Heckington Fen Solar Park

EN010123

Schedule of Changes to the draft Development Consent Order

Document Reference: Pre-ExA.ChangeApp.SCHDCO.V1

Figure 3.9 Change of Notification Areas at Bicker Fen National Grid Substation

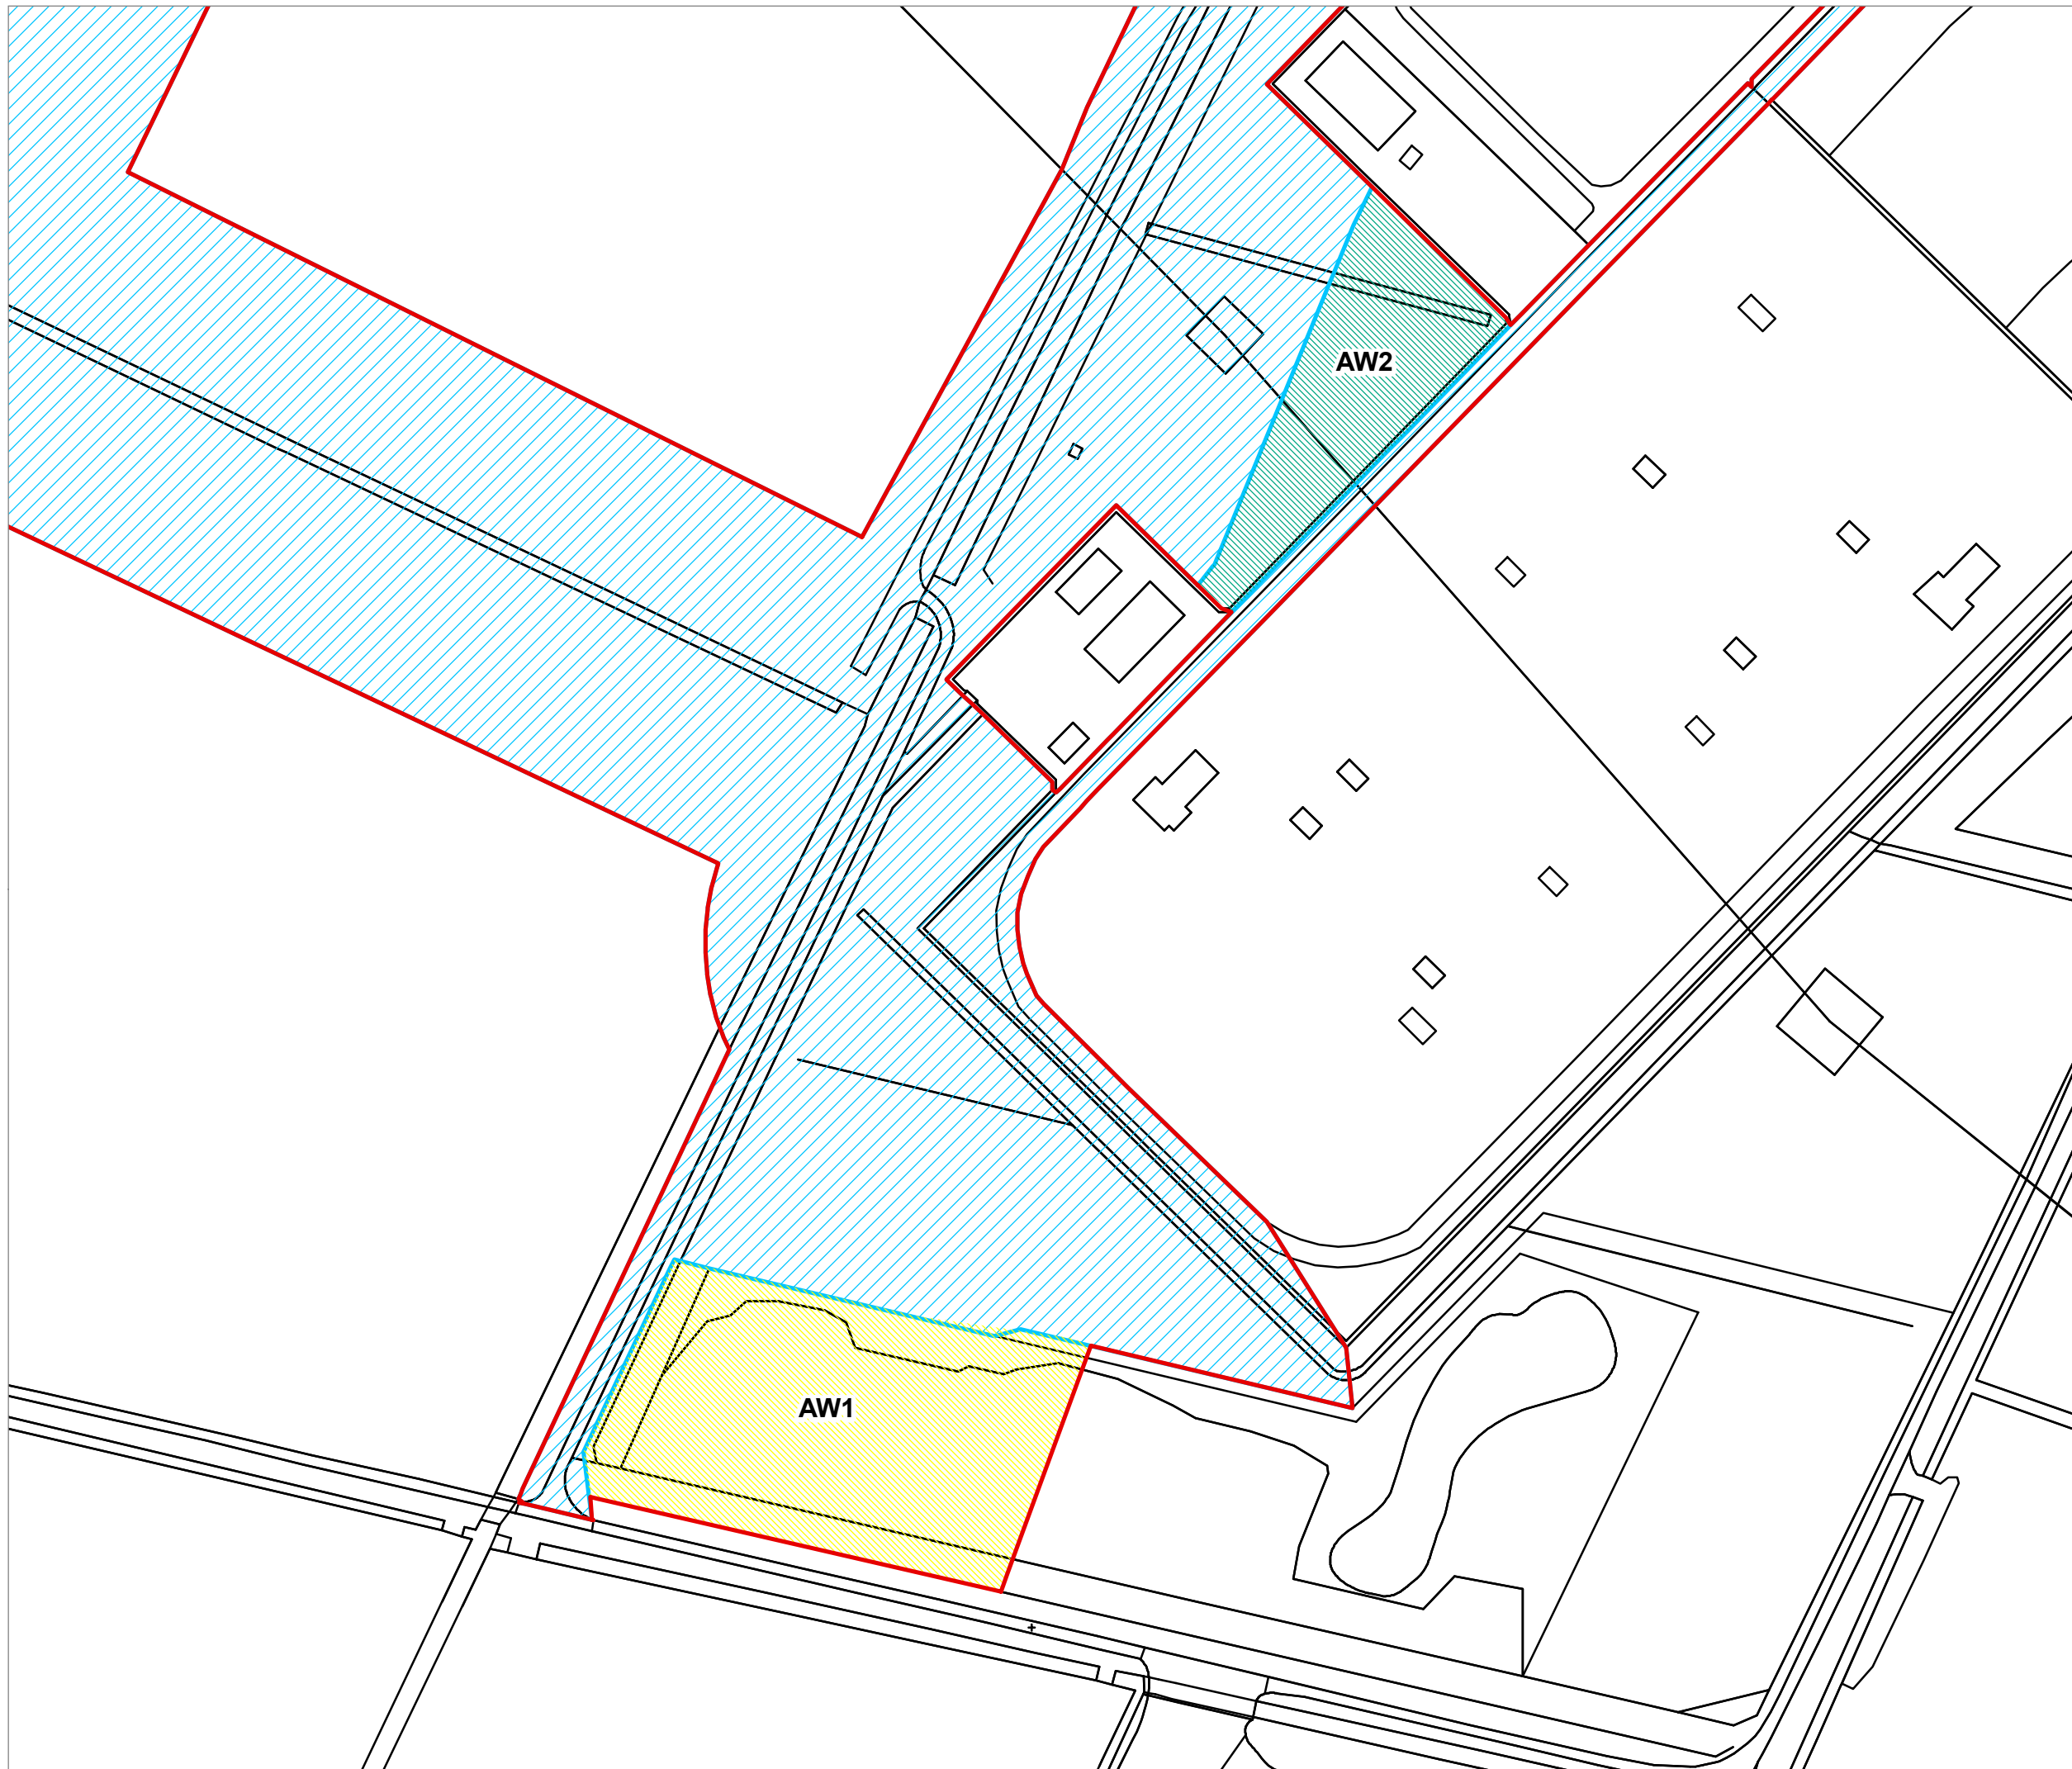
5.	Article 45	NGET	Following discussions with NGET and for the purpose of the applicant's project, NGET will be required to extend the Existing Substation and carry out works on land not included as part of the original DCO application in order to facilitate the connection of the Applicant's project.	<p>An additional article has been inserted as Article 45, which reads as follows:</p> <p>"45.-(1) <i>If NGET elects to undertake any elements of the works described in Work No. 6B or 6C pursuant to planning permission granted under Part 3 of the 1990 Act or Article 3 of the 2015 Order then the requirements contained in Schedule 2 will not have effect in so far as they relate to those works and NGET</i></p>	3

6.	Schedule 1	NGET	<p>Per NGET's request for the DCO to grant it the benefit of rights for the purpose of carrying out the Existing Substation extension, Work Nos. 5 to 7 have been updated to cover the additional scope of works required for the Existing Substation extension.</p>	<p>Work No.5 has been updated as follows:</p> <p>"Work No. 5— works to lay electrical cables between Work No. 4 and Work No. 6A."</p> <p>Work No. 6 has been divided into Work No. 6A, Work No. 6B and Work No. 6C as follows:</p>	3

<p>Work No. 6 an extension to 6A— creation of a new generation bay and associated works at the existing substation, including—</p> <ul style="list-style-type: none"> (a) an electrical bays to connect into the existing network within the existing substation at Work No. 6B, including associated outdoor air insulated switchgear (AIS) or indoor gas insulated switchgear (GIS) and electrical apparatus (b) switchgear including, circuit breakers, disconnectors and earth switches; (b) substation electrical apparatus, including bus-bars, steel supports, insulation posts, cable sealing ends, surge arrestors, instrument transformers; (c) control building; and (d) underground and above ground electrical cables and electrical connectors, including cables for power, control and communication with electrical bays and to connect into the existing network within the existing substation, including associated switchgear and electrical apparatus Work No. 6B, including associated outdoor AIS or indoor GIS and electrical apparatus. <p>Work No. 6B— an extension to the existing substation, including—</p> <ul style="list-style-type: none"> (a) outdoor AIS or indoor GIS, including circuit breakers, disconnectors and earth switches;

<p><i>(b) substation electrical apparatus, including bus-bars, bus-section and a bus-coupler, steel supports, insulation posts, cable sealing ends, surge arrestors, instrument transformers; and</i></p> <p><i>(c) underground and above ground electrical cables and electrical conductors, including cables for power, control and communication with electrical bays and to connect into Work No. 6A and the existing network within the existing substation, including associated outdoor AIS or indoor GIS and electrical apparatus.</i></p> <p>Work No. 6C— works in connection with the extension to the existing substation, including—</p> <p><i>(a) a cable sealing end compound and construction of a new circuit bay connecting into the existing substation; and</i></p> <p><i>(b) underground and above ground electrical cables and electrical conductors, connecting the existing 400kV transmission tower and the new feeder bay.</i></p> <p>Work No. 7— two temporary laydown areas in connection with Work No. 5 and Work No. 6A, 6B, and 6C including—..."</p>
